The Member-Secretary,
Madras Metropolitan
Development Authority,
No.8, Gandhi Irwin Road,
Madras 600 008.

Lr.No.D.Dis.A3/11766/90 Dated: 28.12.90.

Sub: MMDA - Planning Permission - Proposed
Construction of residential building
in Plot No.72D at S.No.335/1 of Padi
village - Approval - Regarding.

SITE / GROUND FLOOR PLAN (plot no: 72D)

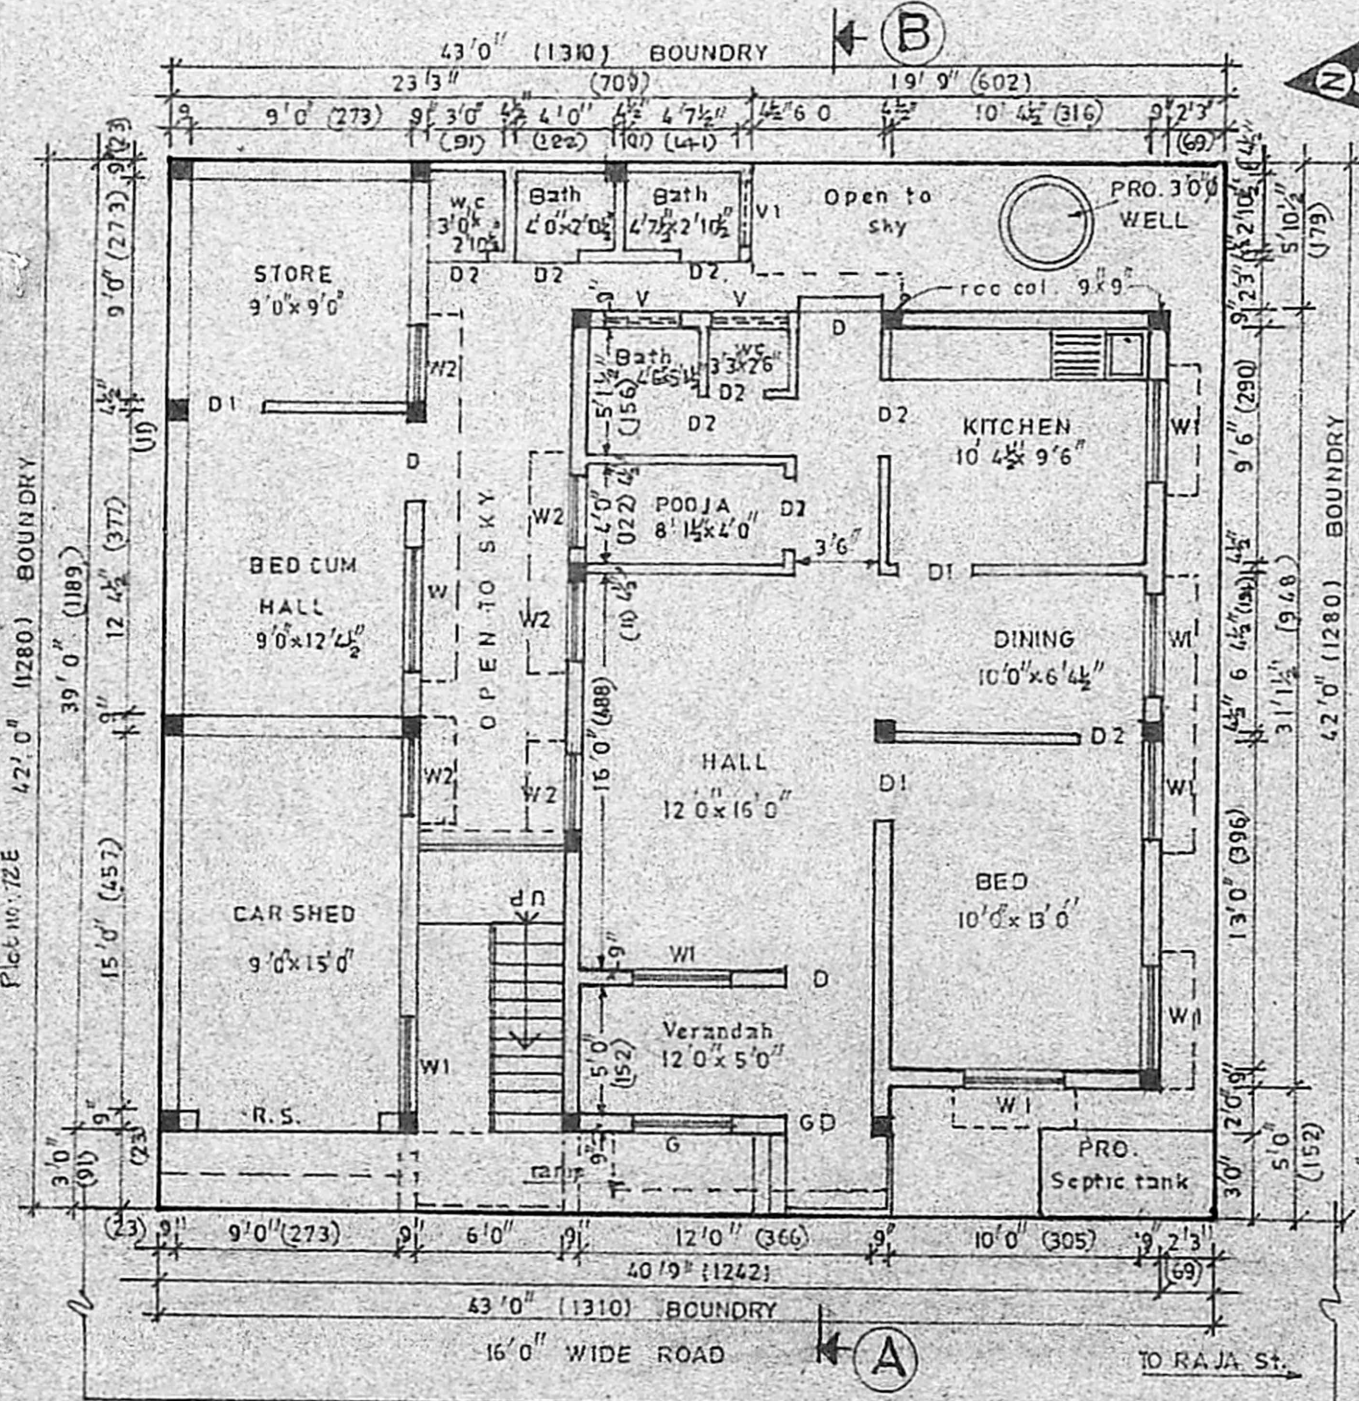
2. The revised plans submitted by the applicant directly to this office was examined and found that the planning permission for the same is issuable by relaxing Front Set Back requirements and also regularising un-authorized sub-division and subject to condition that --

1. The applicant should not building the Store, Bed room & Car shed as shown in the plan.
- ii. 'in the open space within the site to be extent feasible trees be planted and the existing trees preserved'
- iii. 'it was requested to ensure that the plans for the new buildings will incorporate was the approved designs for mosquito-proof overhead tanks and wells'
- iv. 'Other charges as applicable.
